Application No: FP/66/26/PL
Site Address: Rabbit Island Rear of 84 Brooks Lane Bognor Regis PO22 8DN
Description of works: Retention of an existing agricultural barn previously approved under FP/106/23/AG with a total roof height of 4.2m (compared to 2.9m as permitted). This application is in CIL Zone 5 (Zero Rated) as other development.

Thank you for your internet representation made on 8th July 2026 which has been recorded as an objection with the comments as follows:

Drawing: Elevations and floor plan

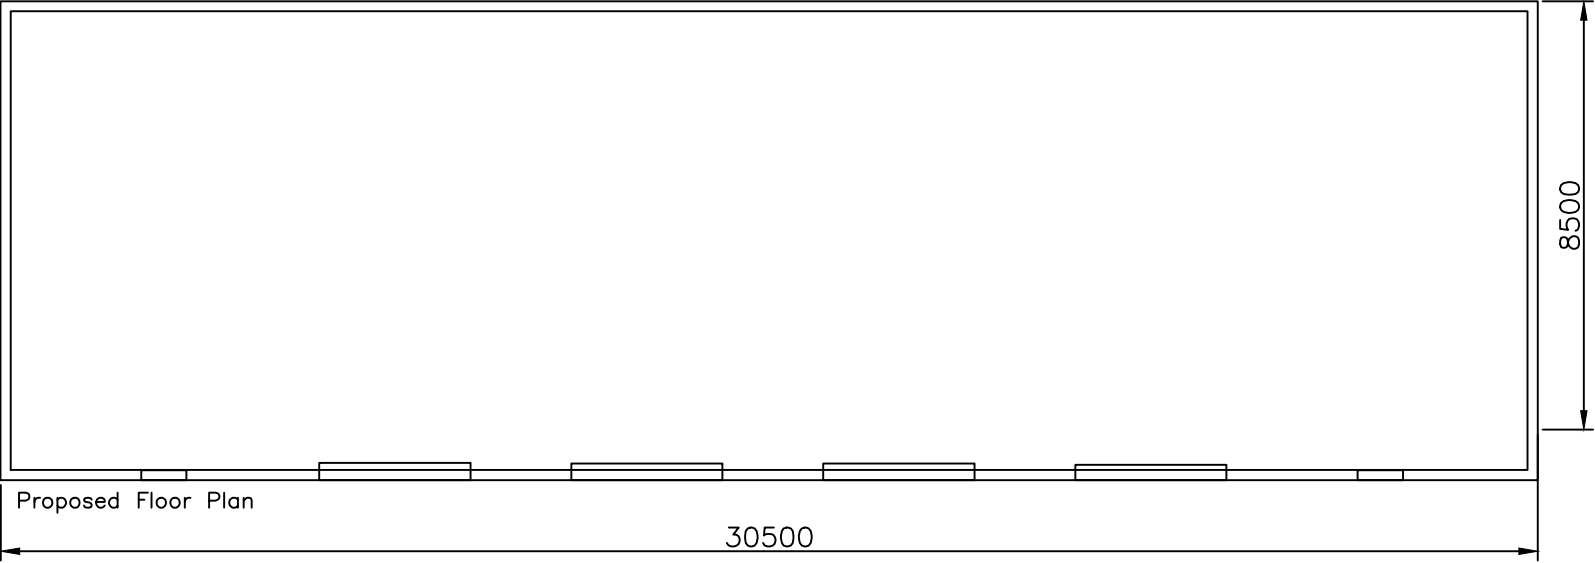
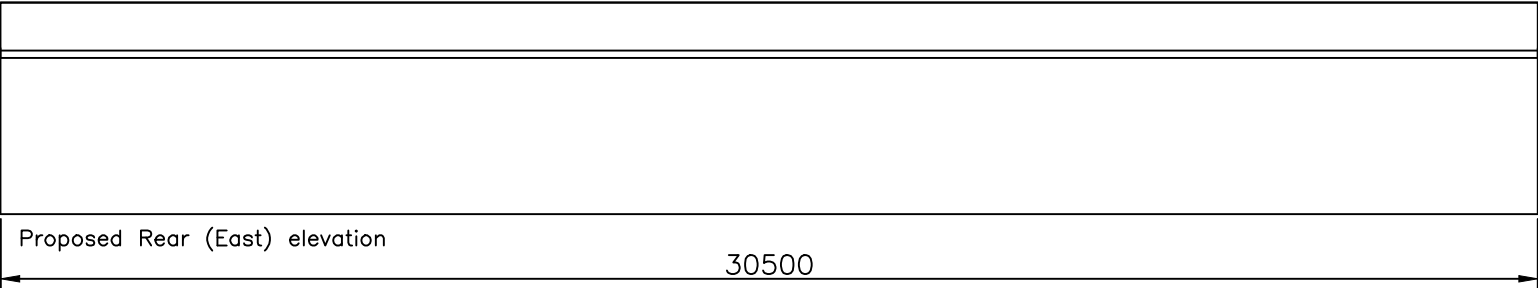
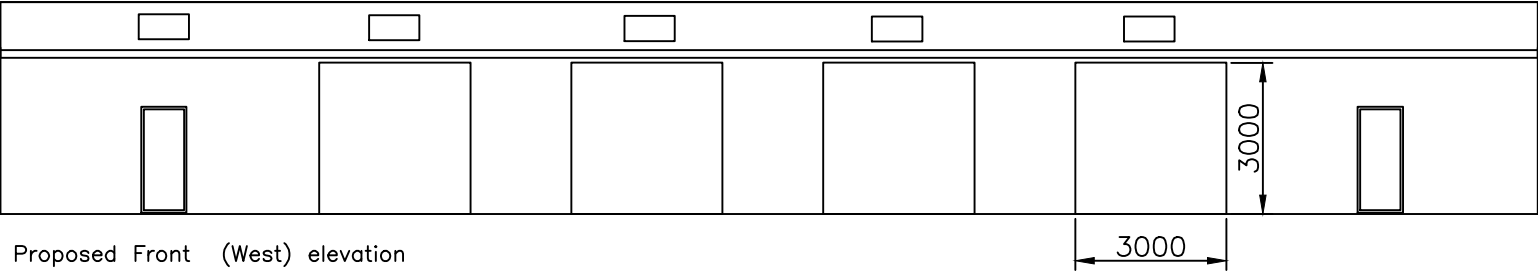
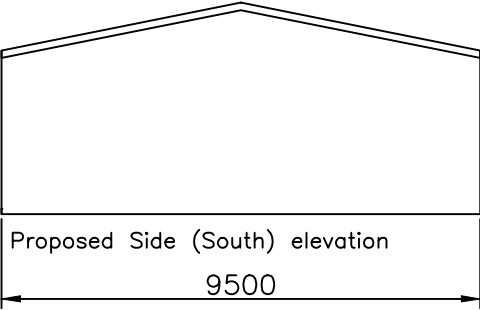
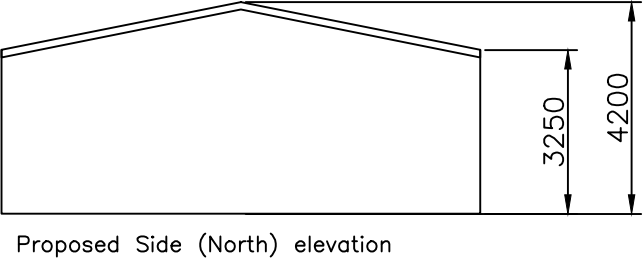
The barn has been proposed to store hay and agricultural equipment in it why has the barn got 4 other doors? was this question asked when a site visit went ahead in February, as it is already mentioned by the above people that he has put the property up for auction on the 15th July no way is it going to be used for agricultural purposes, you only have to walk round the site to see that there is industrial waste that has been dumped on the field and also 3 more diggers have been left in the area between Brooks Lane and the bridge entrance to Rabbit Island.
